30 June 2020

**RE: Response to DPIE Request for Information dated 19 June 2020, State Significant Development (SSD-9813), 36-48 Donnison Street, Gosford.**

Drawing Number
DA-632

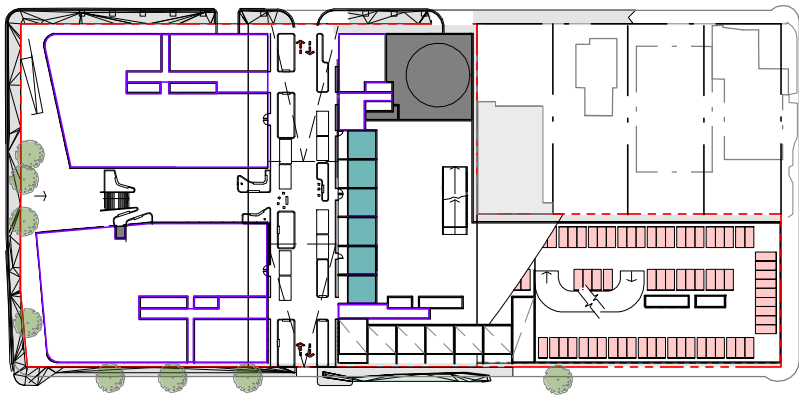
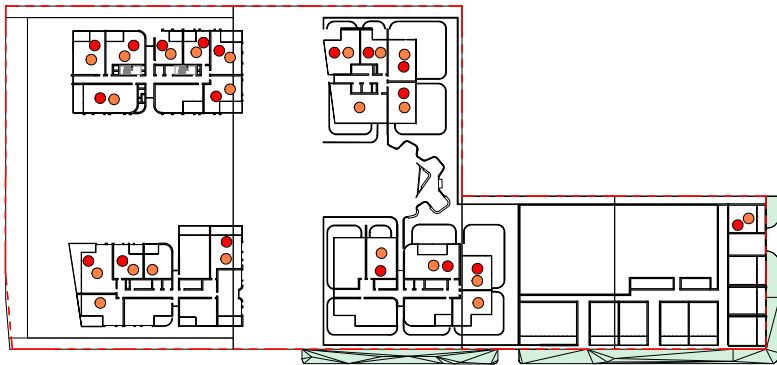
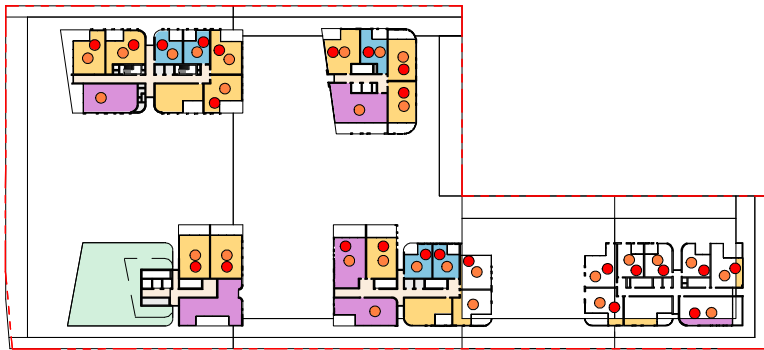
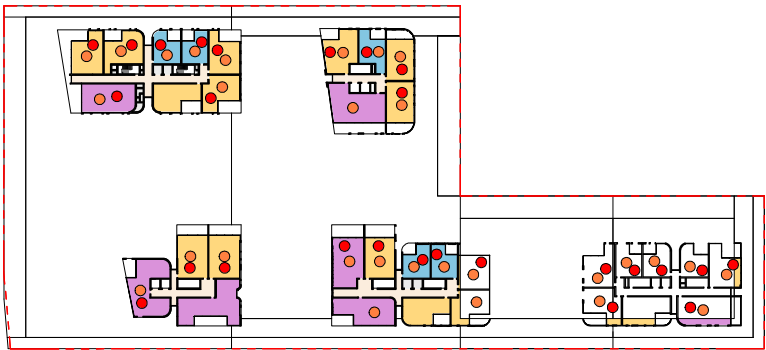
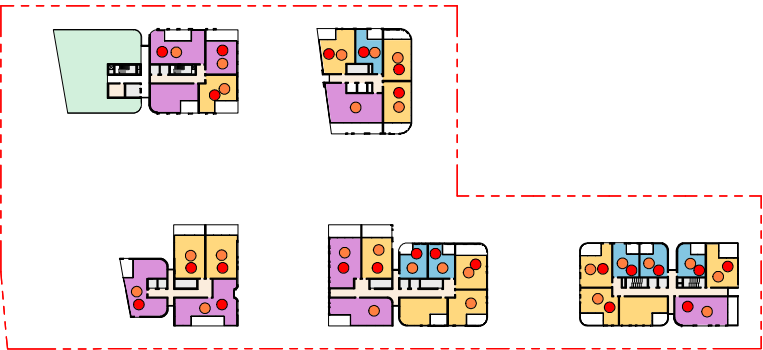
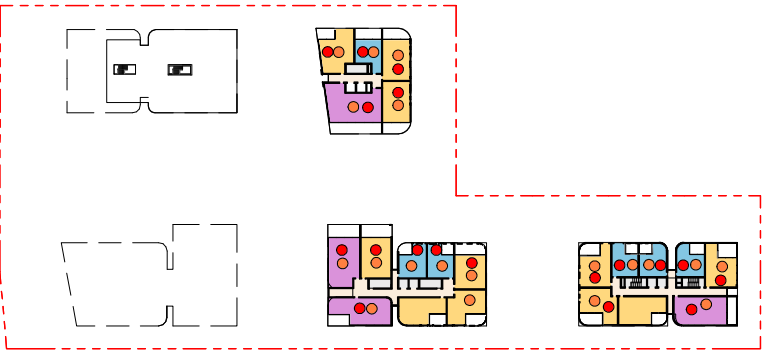
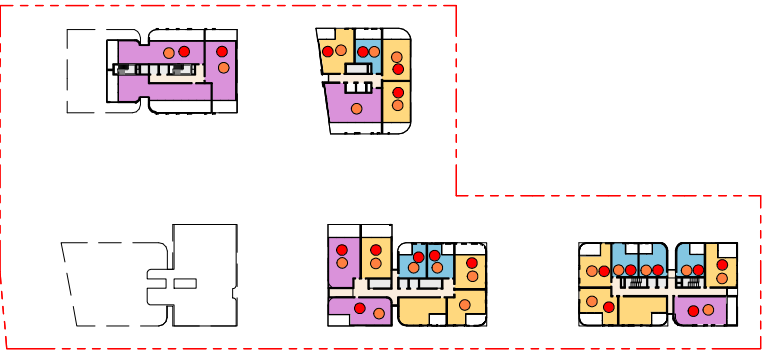
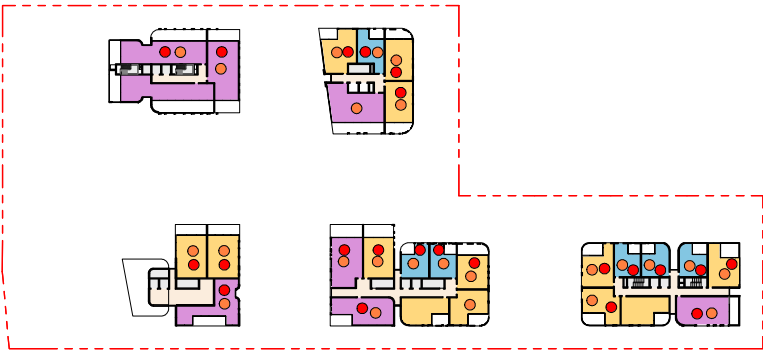
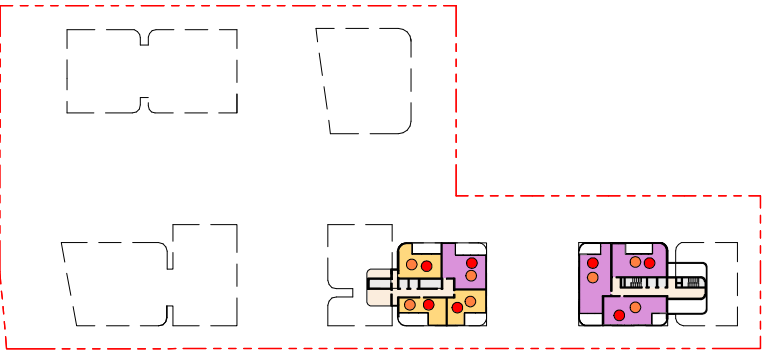
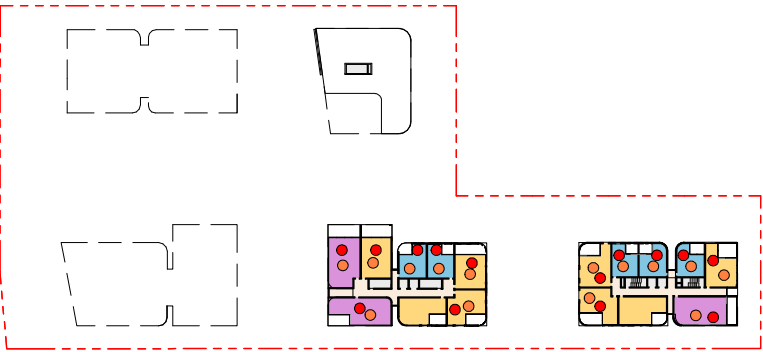
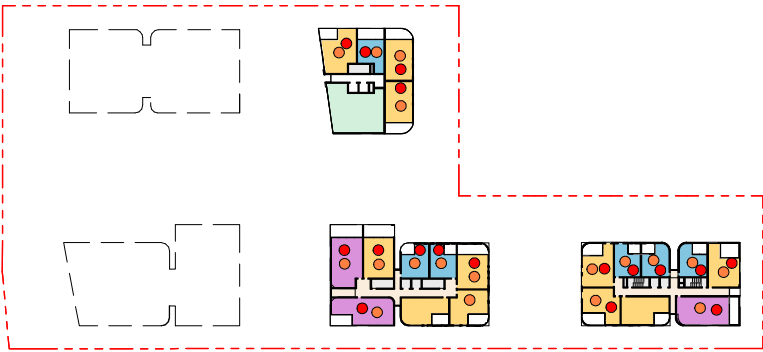
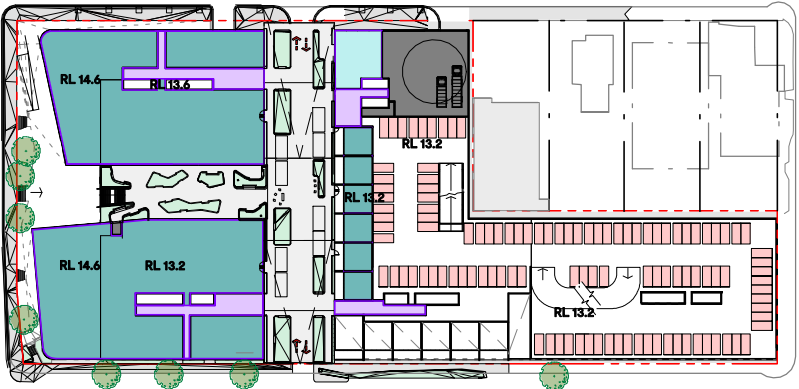
DPIE Item	Response
<p>Please provide an in-principle assessment against ADG 4A-1 (2) and confirm whether the proposal is capable of compliance. The current assessment is against the Sydney metropolitan 4A-1(1) requirement of 70% of apartments for a minimum of 2 hours sunlight, however Gosford falls within 'all other areas' (see definition of Sydney metropolitan area in glossary) and should therefore also be assessed against the 3 hour requirement.</p>	<p>An in-principle assessment has been undertaken by Buchan and an updated SEPP65 report is attached, which includes assessment at both the 2-hour and 3-hour benchmarks.</p> <p>This demonstrates that the concept scheme achieves 2-hours of solar access to greater than 70% of units, and 3-hours of solar access to 68% of units. Given the concept nature of this proposal, this figure is considered to reasonably demonstrate that full compliance with the 3-hour control could be achieved with further design refinement in future stages.</p> <p>However, we also suggest that the 3-hour benchmark is unlikely to be relevant for Gosford moving forward. It is likely that when these solar access provisions were drafted for the <i>Apartment Design Guide</i>, the scale of development now being proposed in the Gosford City Centre was not anticipated. The 2-hour control applies to Sydney, Wollongong, and Newcastle, with Gosford a notable absence given its identification in strategic documentation as the 'capital of the Central Coast' and the significant densities that have been permitted under <i>State Environmental Planning Policy (Gosford City Centre) 2018</i>.</p>
